REF R/190/13/1

I write to register my objections to this proposal on the following grounds:

DRAWING TITLE
PROPOSED ELEVATIONS AND
STREET ELEVATION

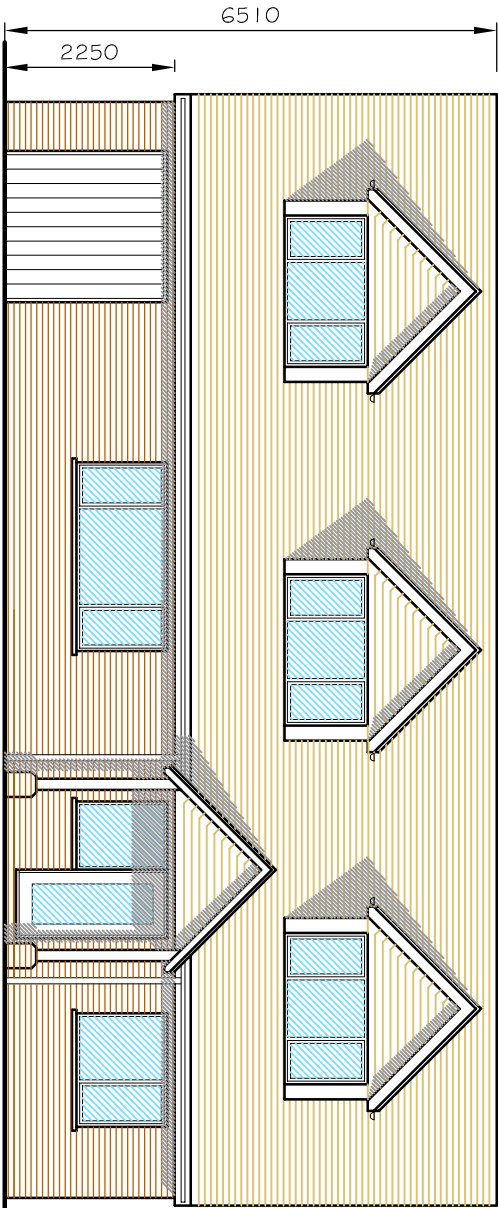
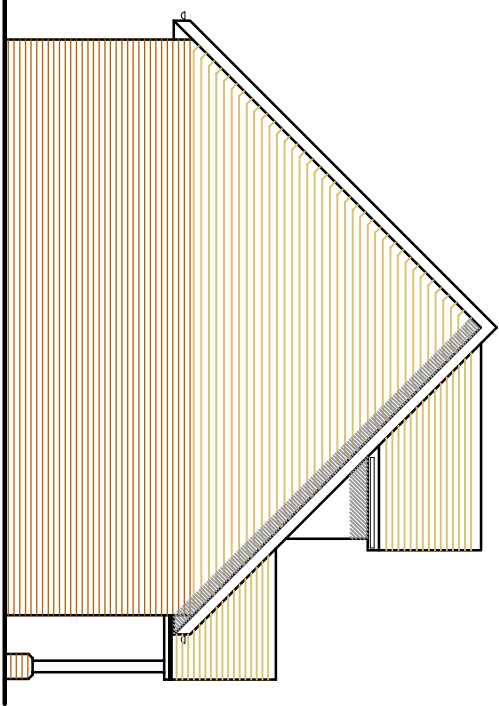
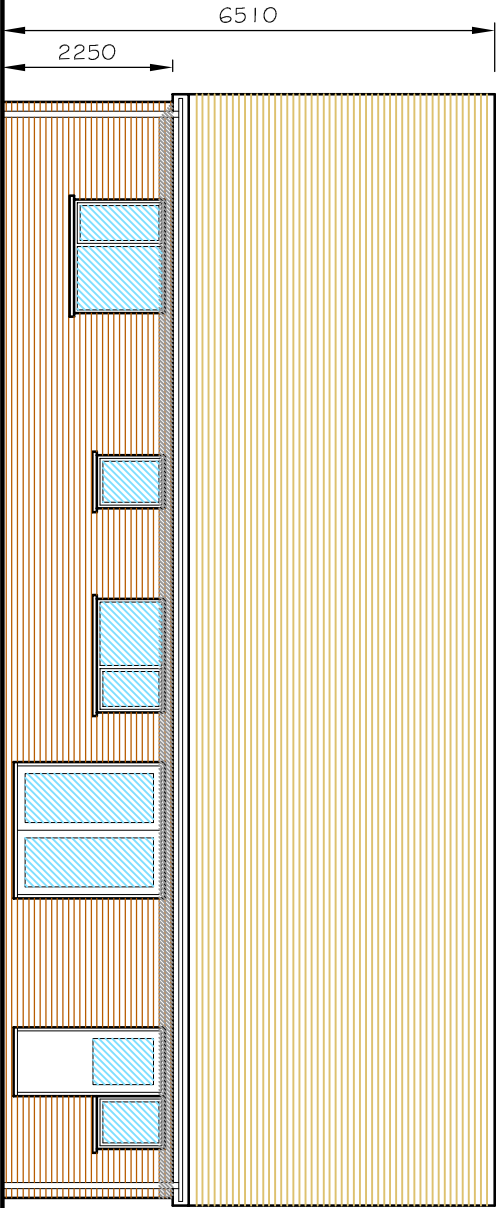
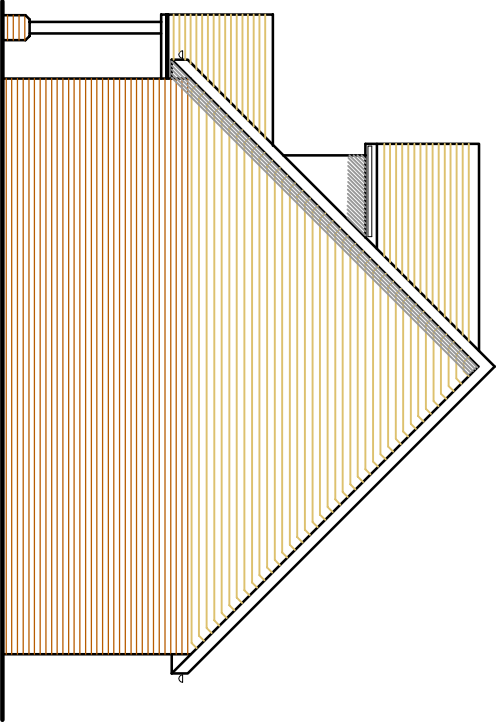
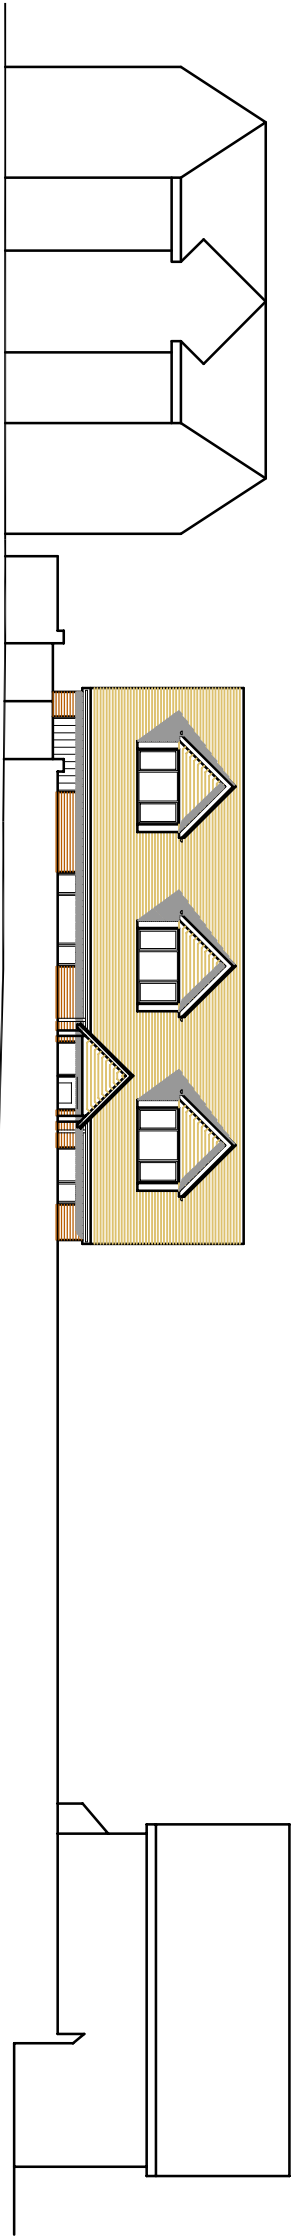
1. The proposal is an over development of the site.
2. It has limited amenity space.
3. It has adverse effects on the property it boards with and the roof design is uncomplimentary to those properties in the respect of views and light.
4. It looks out of place and character with Broadmark Way in terms of design.
5. The rear reduction of the garden space at 20 Broadmark Way has become an issue and the proposal will further compound the problem.
6. The proposal to the site requires primary access from Broadmark Way which requires consent from the Residents Association of Broadmark Way.
